comments on MMC's revised plans/response to comments

Fri, Aug 3, 2018 at 2:47 PM

GRADING & DRAINAGE PLAN - 2

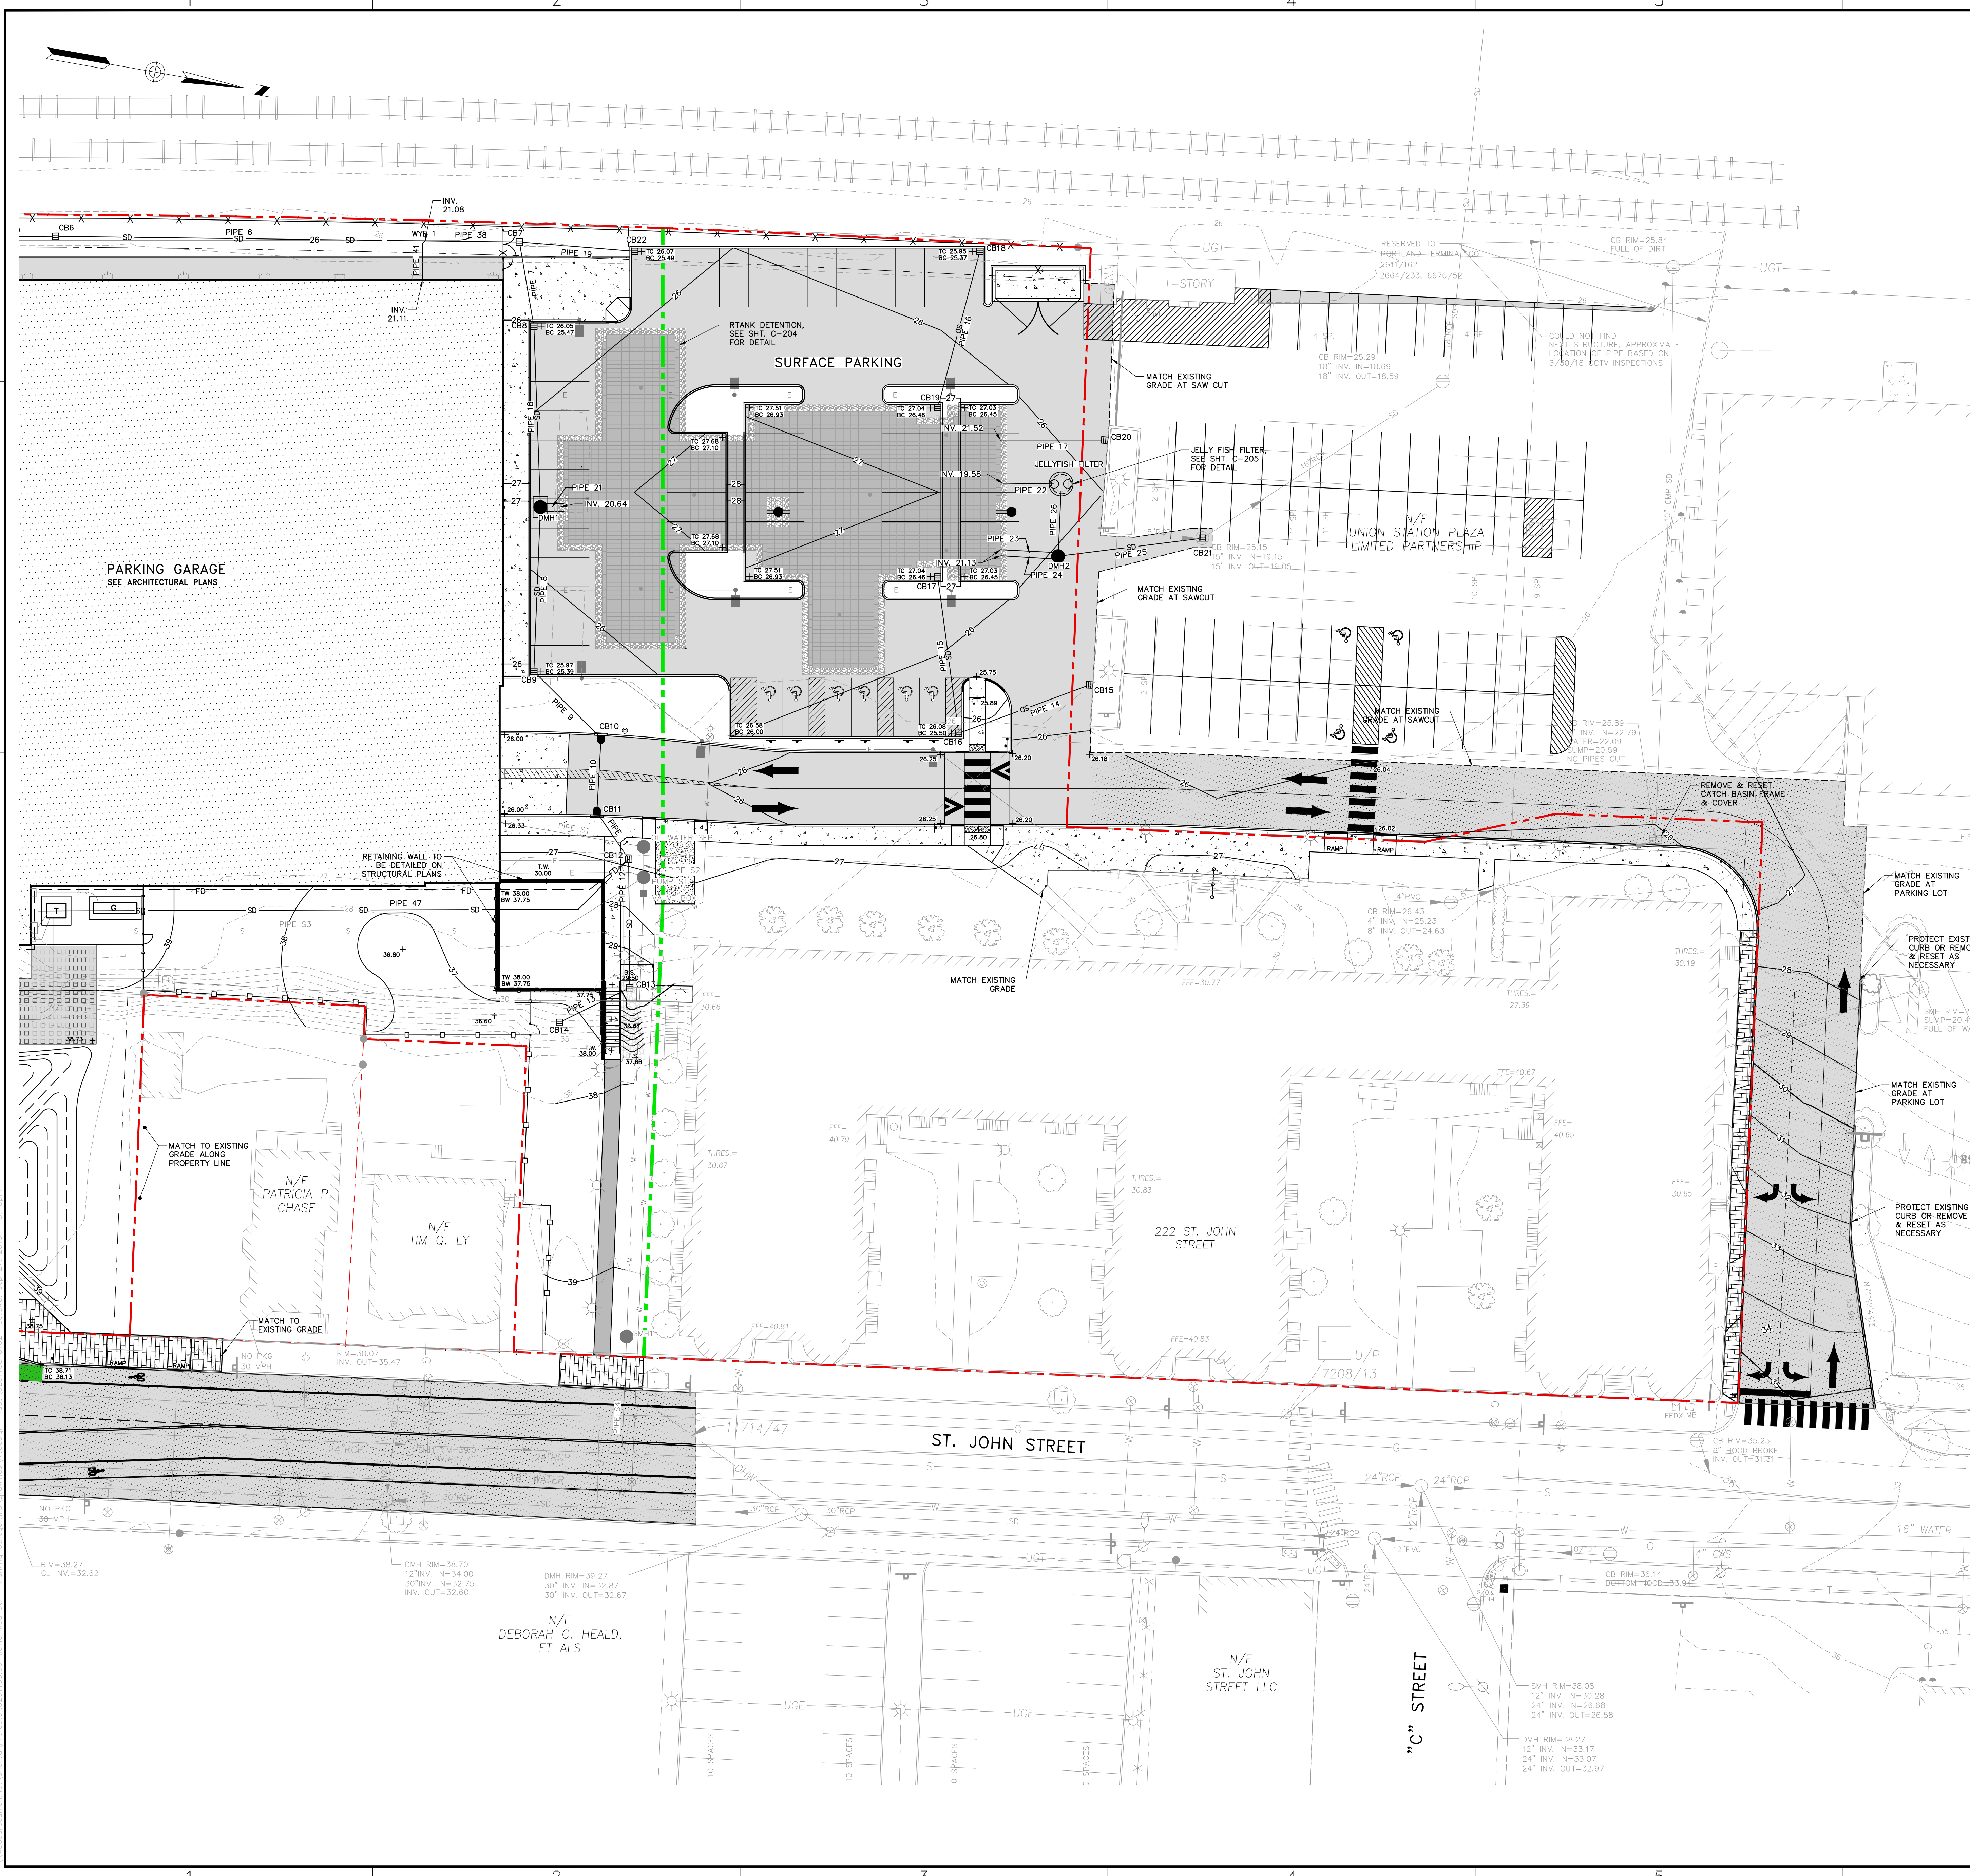
The only item that still concerns me is the location of the private hydrant. We'd like to have it moved further west, between the access road into the lower garage entrance and the surface parking lot.

The proposed location doesn't give us easy access for operations covering the majority of the building.
